Application number: 2020/90761	
What is the application for?:	Demolition of existing workshop and erection of dwelling with garage/workshop at
Address of the site or building:	land between, 12 & 14, Knowl Road, Mirfield, WF14 8DQ
Postcode:	WF14 8DQ

Type of comment: An objection

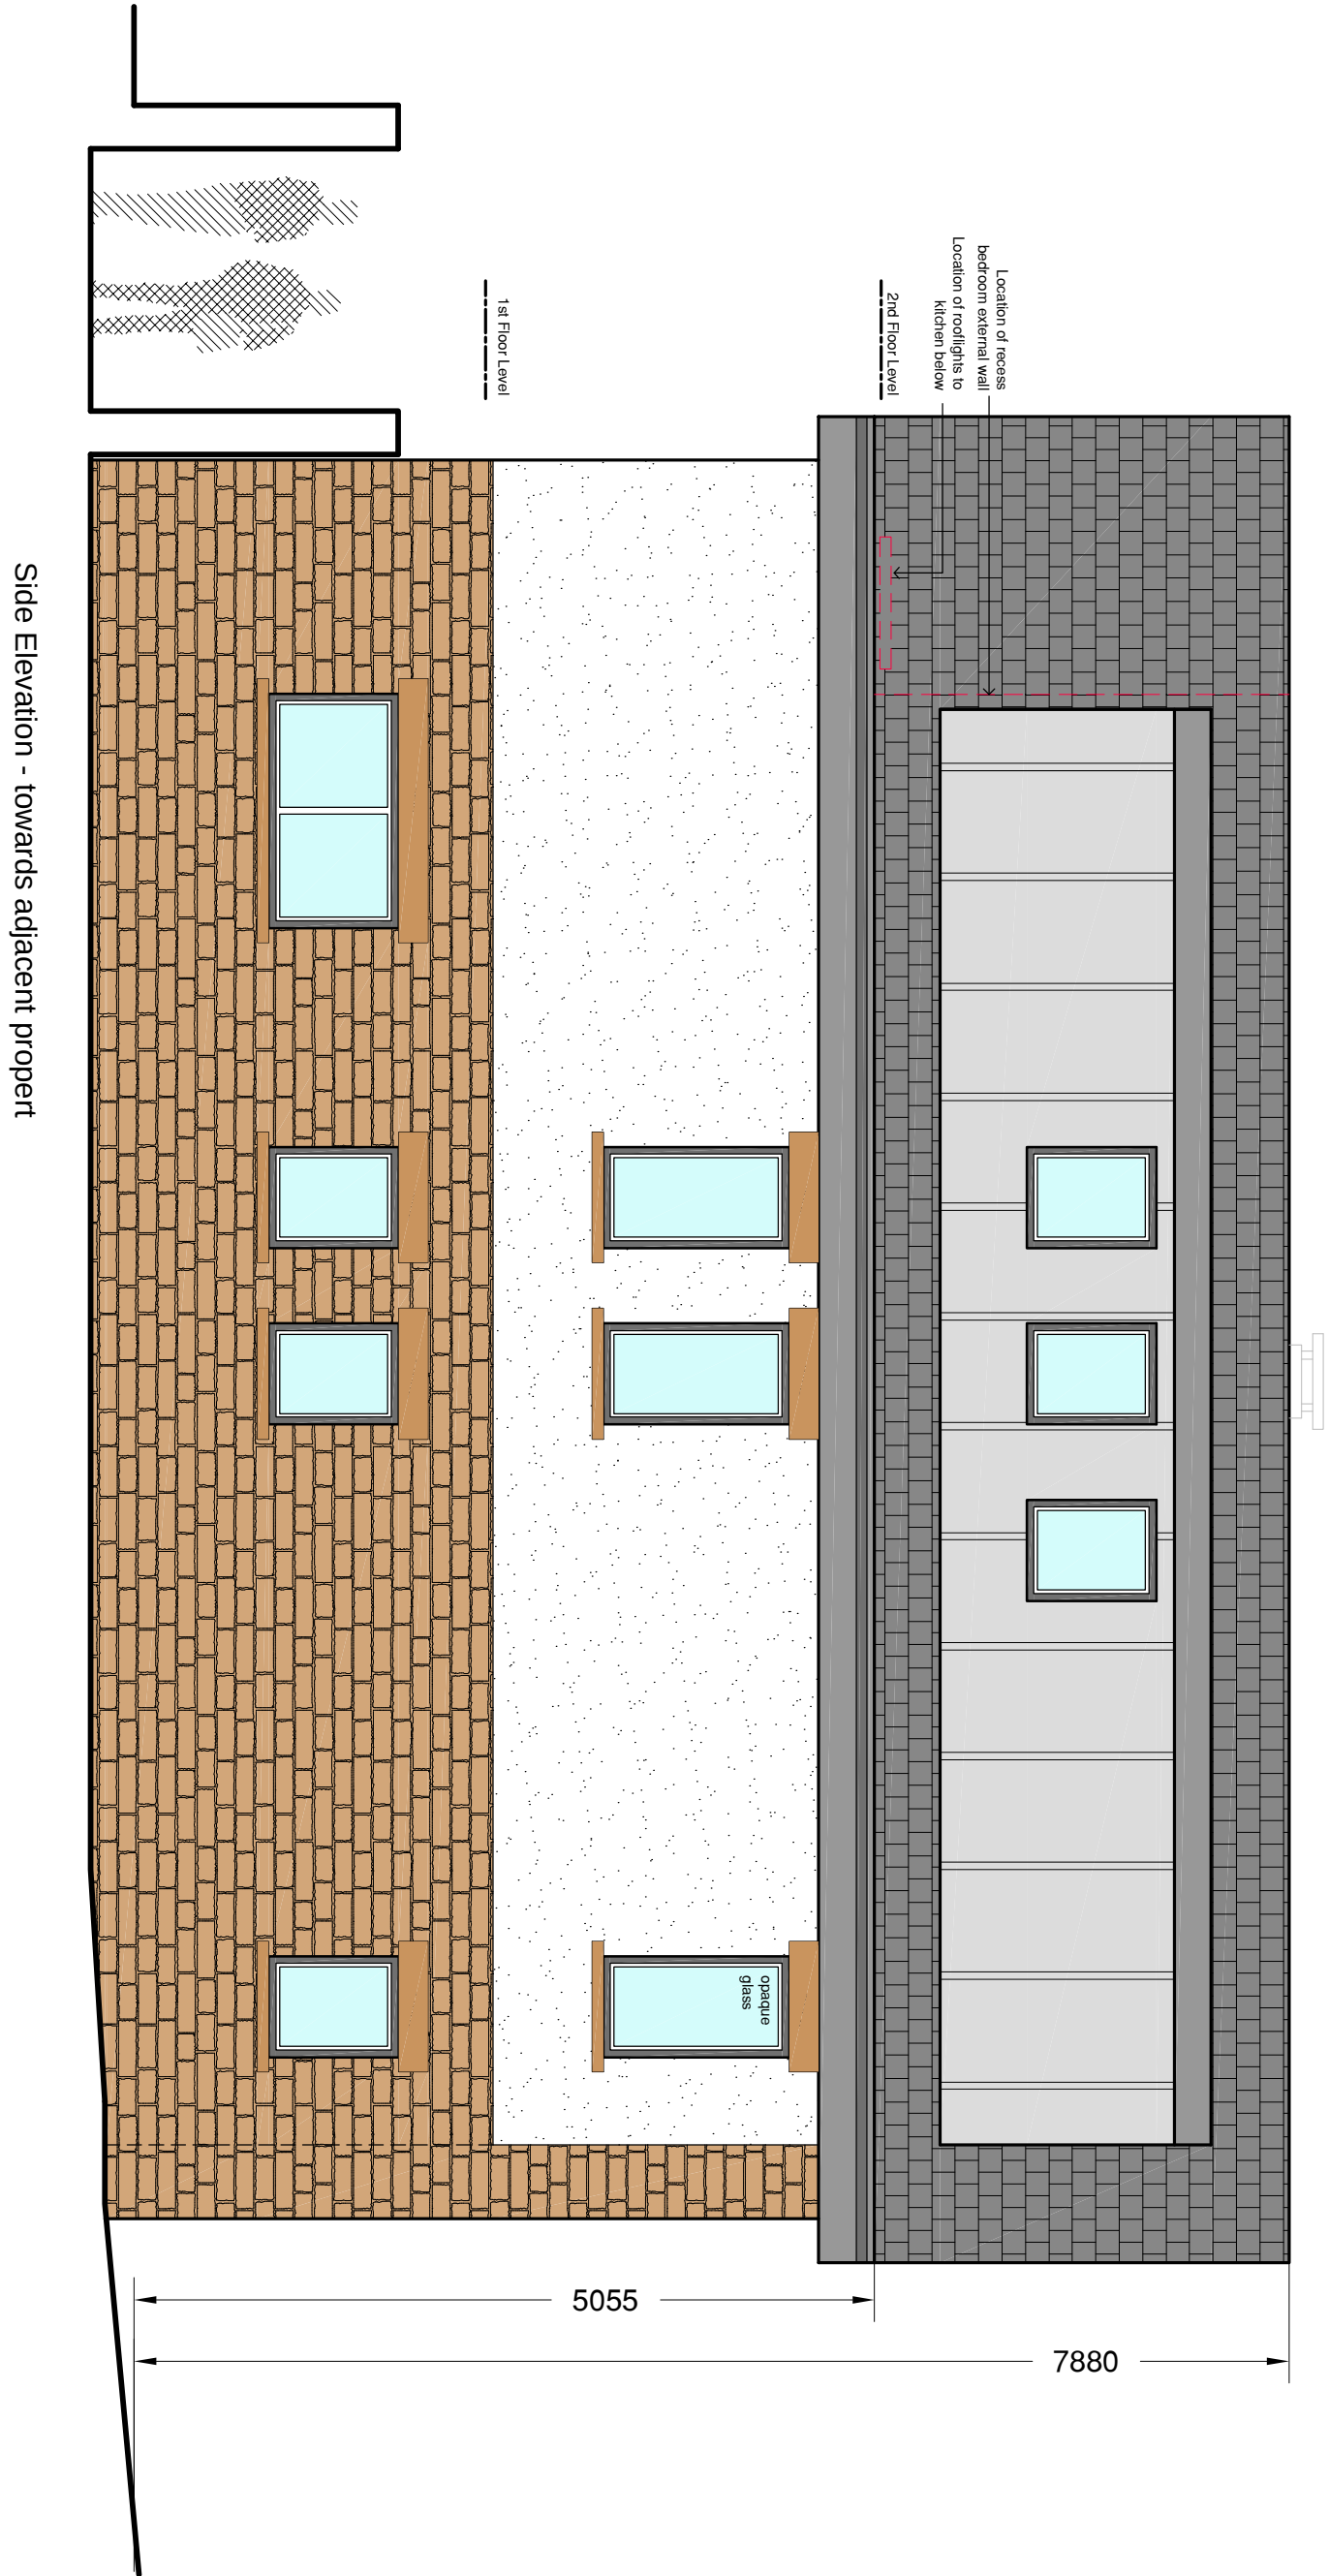
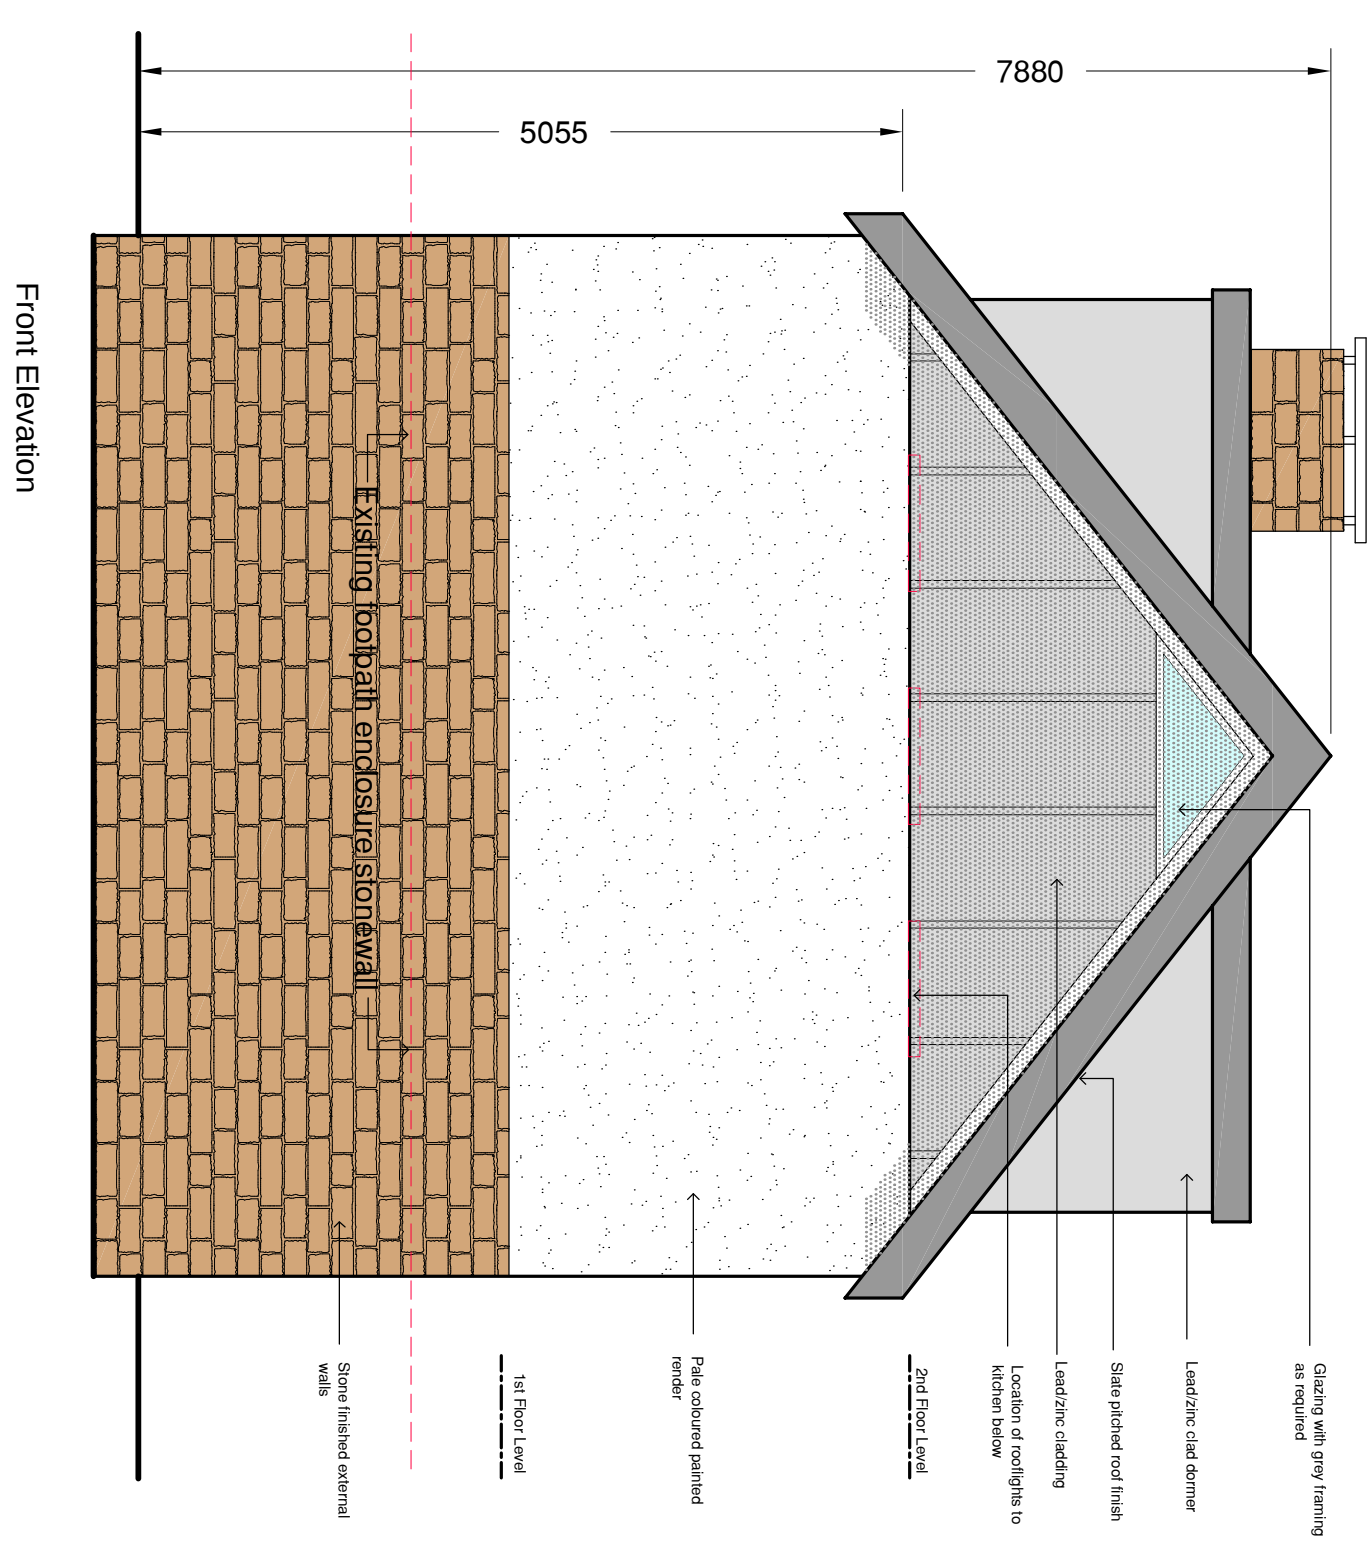
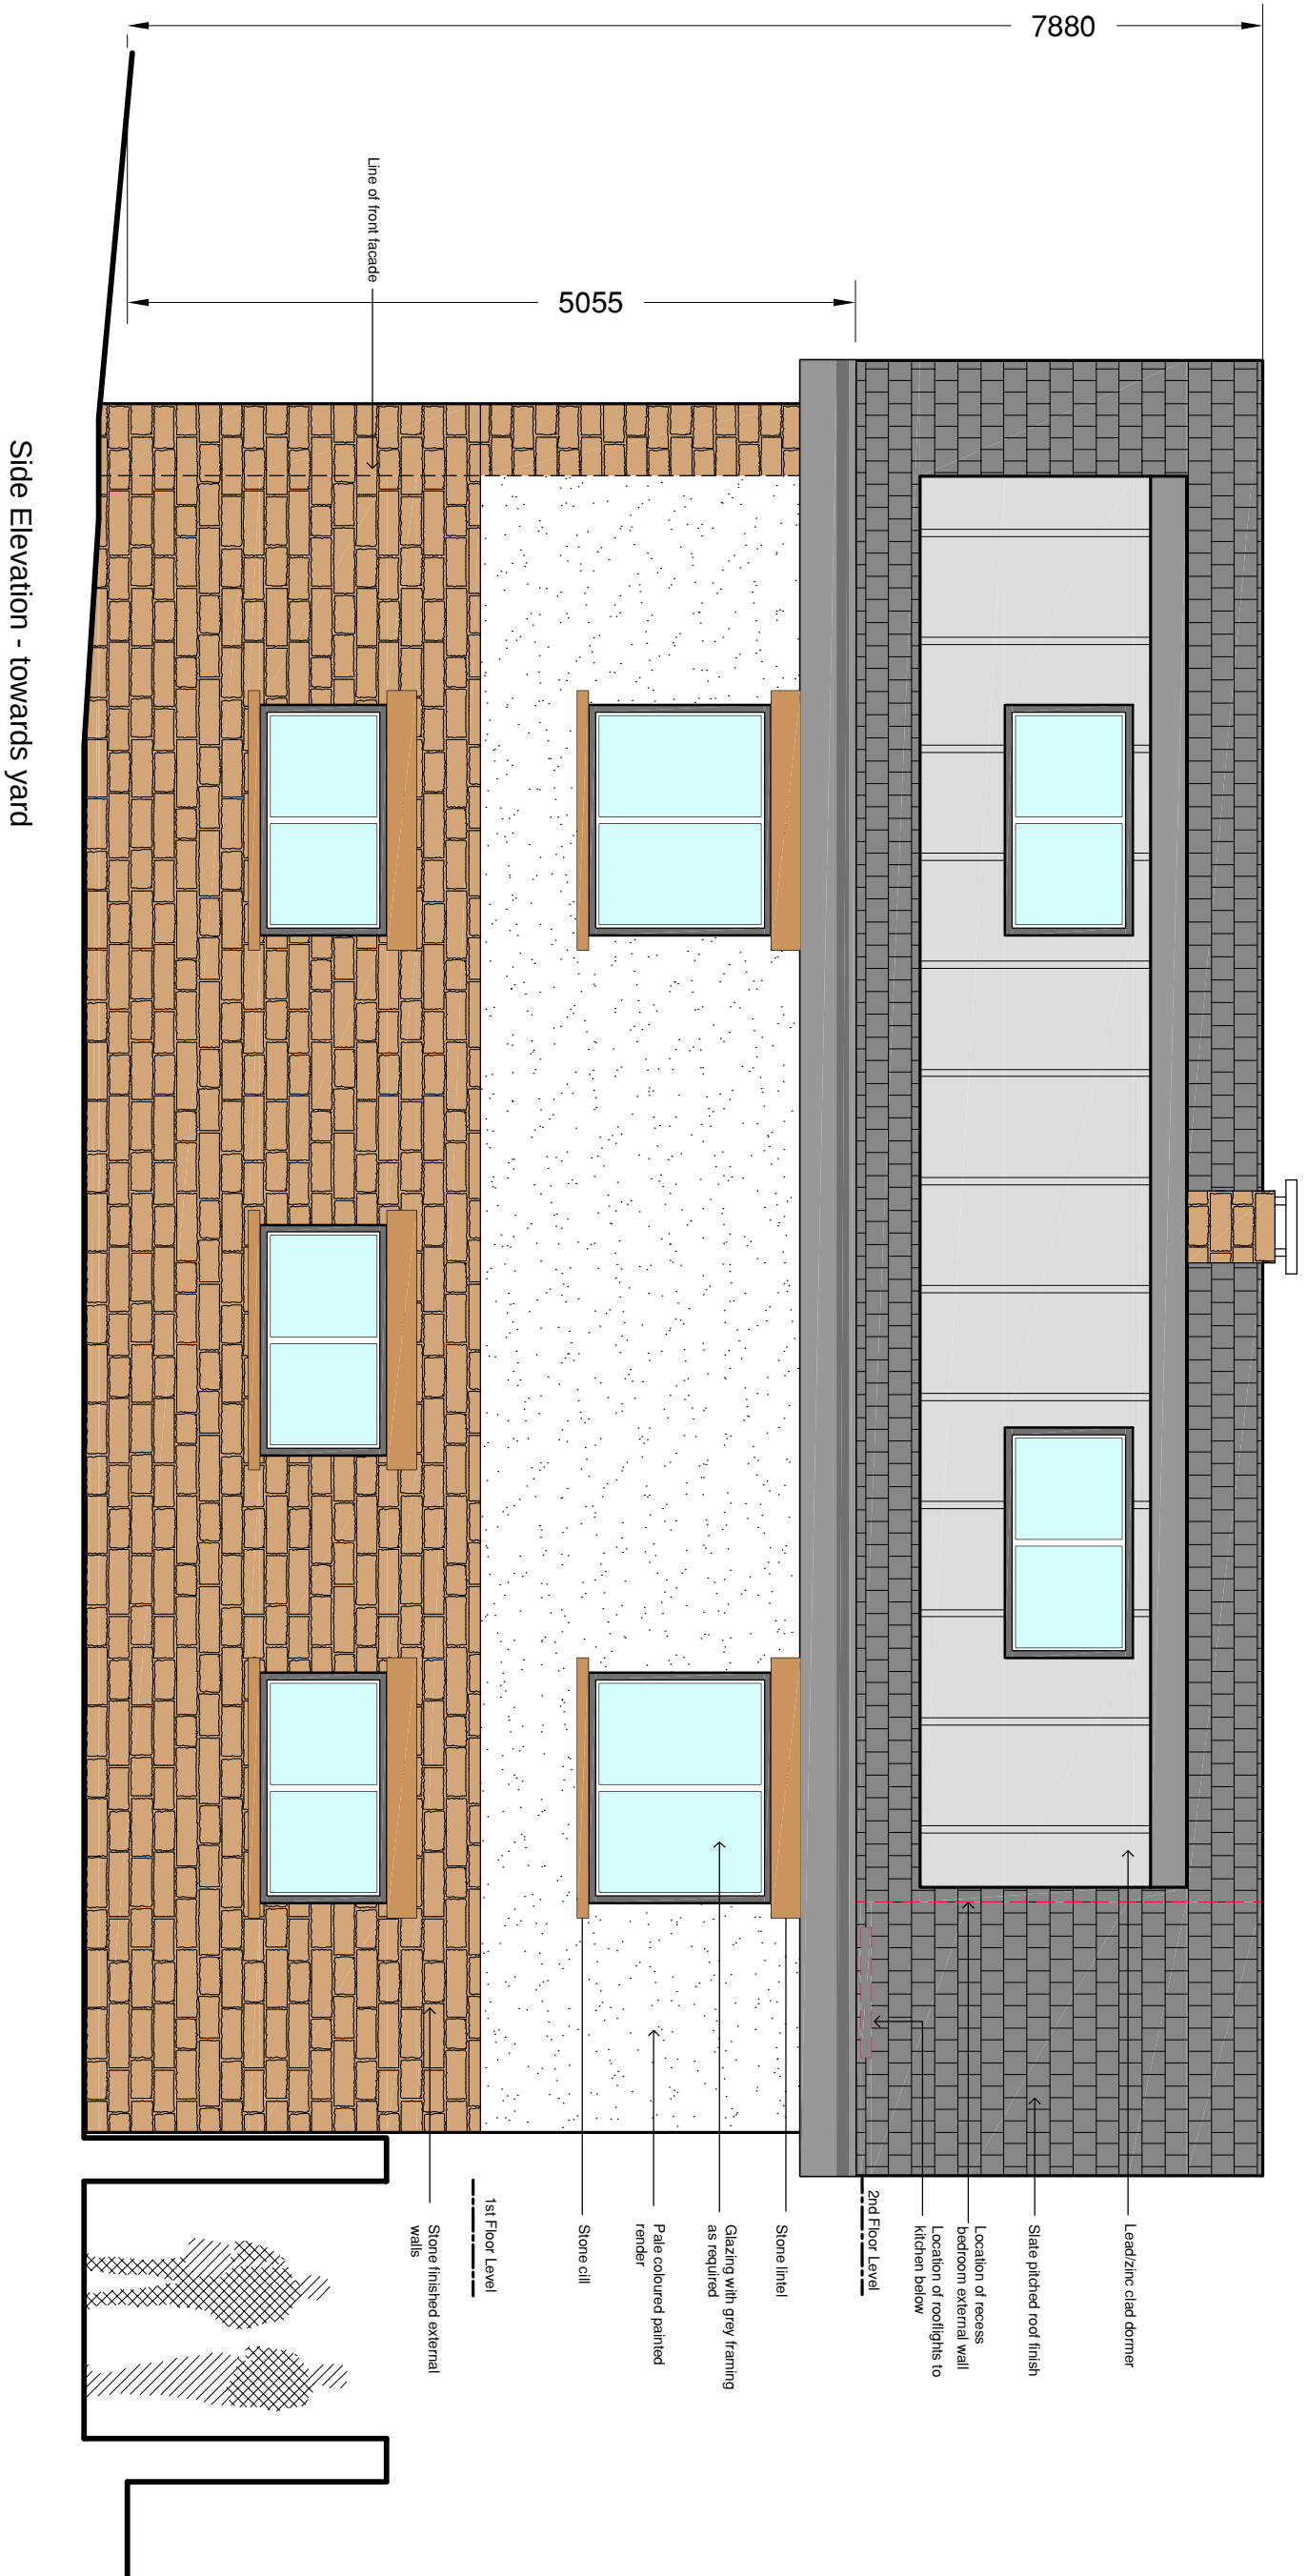
1) The previous application was declined due to the development would result in a large three storey building located in very close proximity to the Public Right of Way to the south of the site which would result in an overbearing impact on the users of this footpath. This second application shows a building of a very similar height, the main difference the third floor being a Dormer style rather than simply a pitched roof - this objection therefore still stands.

2) The previous application was declined due to the development would not promote good design, failing to respect the local character of the area and context in which it would be located. The dwelling would detract from the areas as a result of the mixed palette of materials, none of which are evident in surrounding dwellings which are of traditional appearance. The second application shows a building which has a fully glazed first and second floor fronts to the building, along with render with a Juliet balcony. As a result of poor siting of the dwelling in a cramped site, the proposed development represents poor design and overdevelopment of the application site - this objection therefore still stands.

4) The previous application was declined as by virtue of the proximity of the proposed dwelling to the existing dwellings surrounding the site and the positioning of openings and windows to the front of the proposed dwelling, it would result in a detrimental overbearing and overlooking impact on nos. 10, 14 and 16 Knowl Road, failing to ensure that the existing occupiers of surrounding development would have a high standard of amenity which is required- this objection still stands.
